Able Marine Energy Park

Material Change 2

**ABLE MARINE ENERGY PARK MATERIAL CHANGE 2 (AMEP MC2)
APPLICANT'S COMMENTS ON THE RELEVANT REPRESENTATIONS**

December 2021

Figure 8-14: Google earth Imagery of Hawkins Point (2007 and 2019)

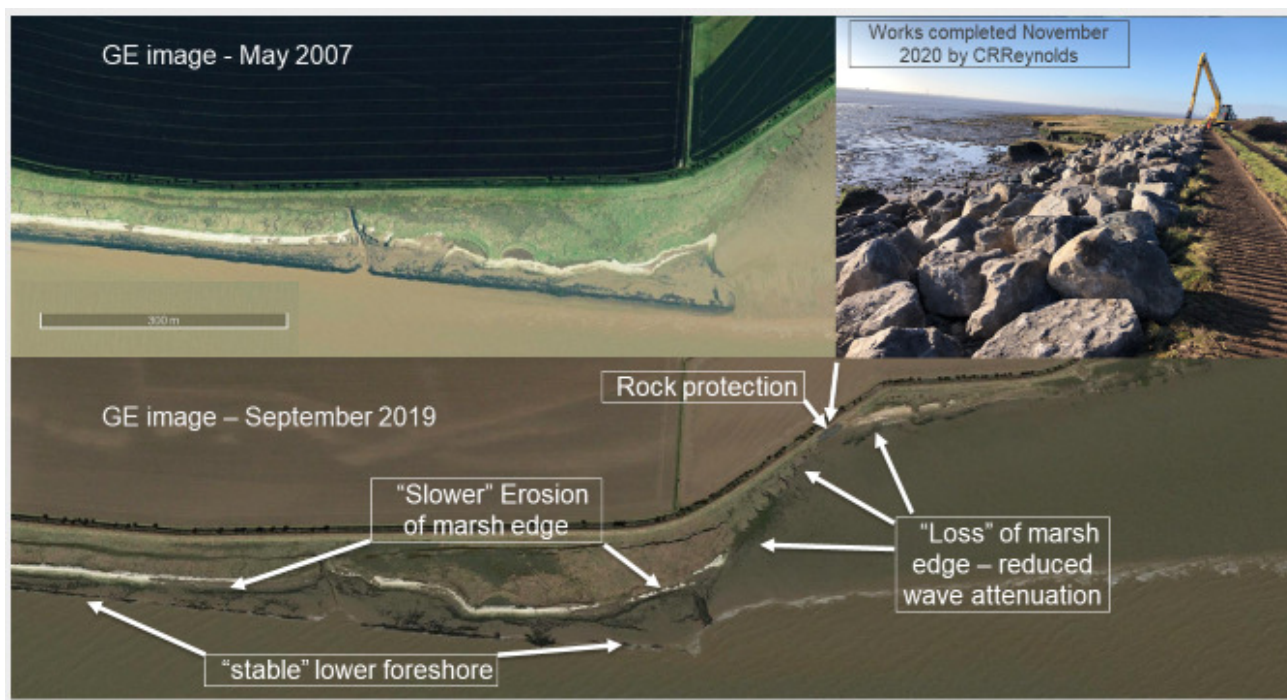
4.1 Impact of changes to hydrodynamics on Hawkins Point (Section 8.4.36 onwards): One wave condition was chosen to carry out this assessment, but it is not clear why this particular condition, and only one, was chosen. We, therefore, request more clarity on this in order to provide confidence in the conclusions reached.

4.3 If these points can be clarified, the conclusion that there is limited impact on the currently eroding section seems reasonable. However, this assessment does also indicate some increasing wave activity which could result in foreshore erosion to the west of Hawkins Point (8.4.39). Whilst this section of the foreshore is currently stable, the potential impact here needs some further consideration in regards to risk to habitat/flood defences.

Figure 8-23: Modelled changes to peak mean spring tide ebb flows (AMEP Amended Quay layout minus updated baseline).

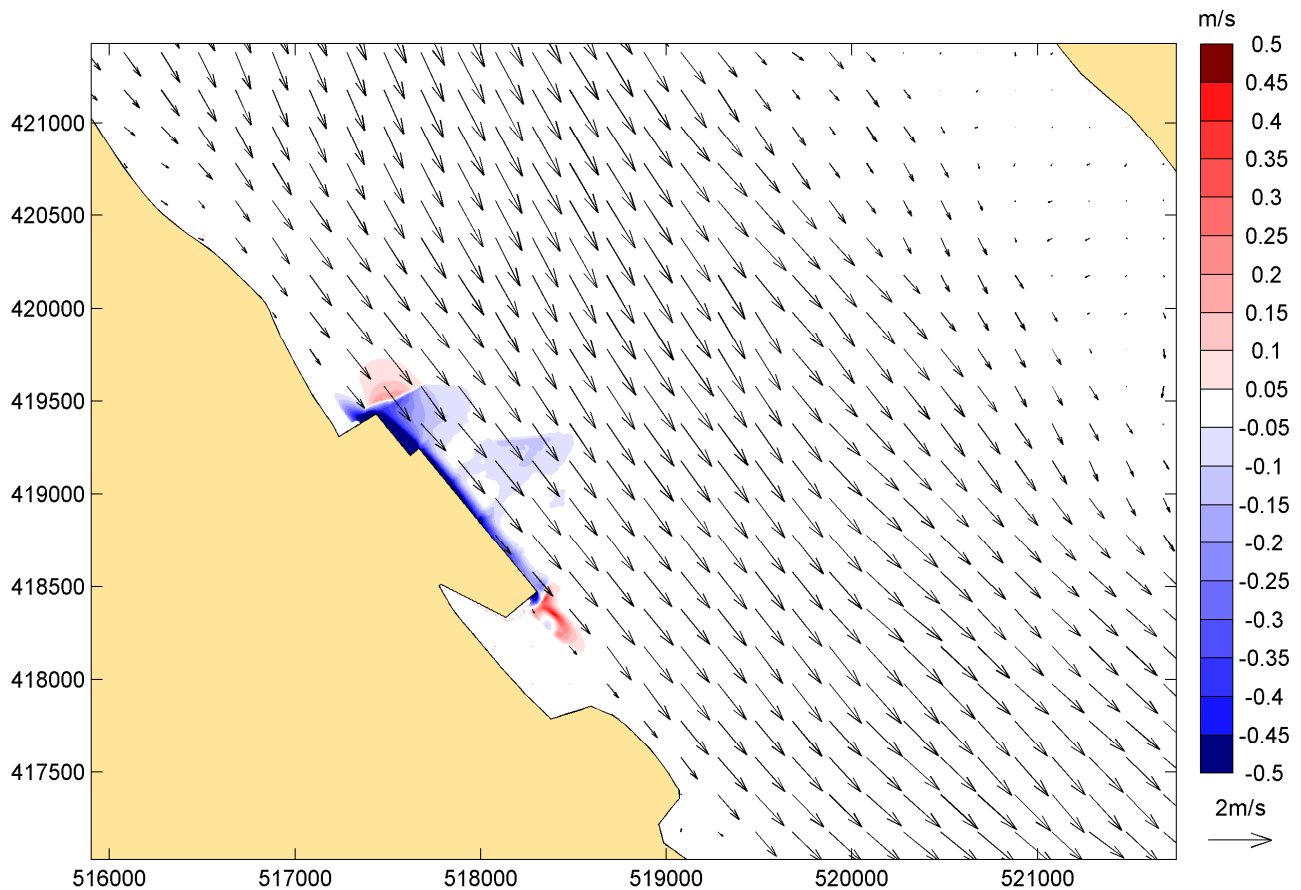
Paragraph 8.4.73 states that 'The proposed AMEP Amended Quay leads to no significant change in assessed impacts to flood tide flows compared to the consented layout. During the ebb tide, a localised region of flow acceleration is predicted off the downstream end of the quay. This initial change may diminish with time but should be noted'.

4.6 To safeguard any consequences from the potential flow acceleration during the ebb tide off the downstream end of the quay, we require the additional mitigation set out in 8.5.2 to be undertaken, and included/secured using the appropriate mechanism (e.g. Marine Licence, Marine Environmental Management and Monitoring Plan etc, or monitoring legal agreement with the Agency). Currently there is no time limit specified in 8.5.2 for monitoring aspects - we require this to be for a minimum of 10 years. We also request that the applicant indicates what remedial action they will implement if this risk is realised.

Figure 8-39: Recent changes to local bathymetry and intertidal levels (difference shown in metres with positive or red showing accretion)

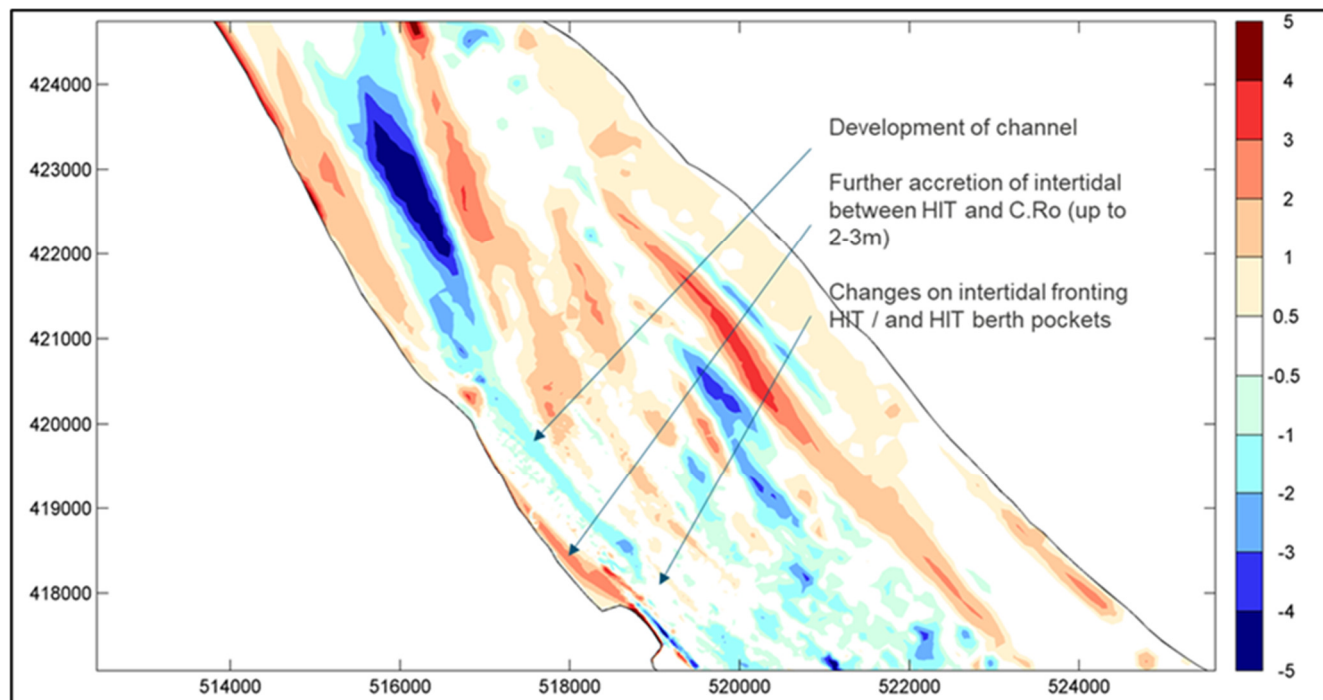
There is a typo in paragraph 8.4.69 where Figure 8.39 is erroneously referenced as 8.40. 5.0
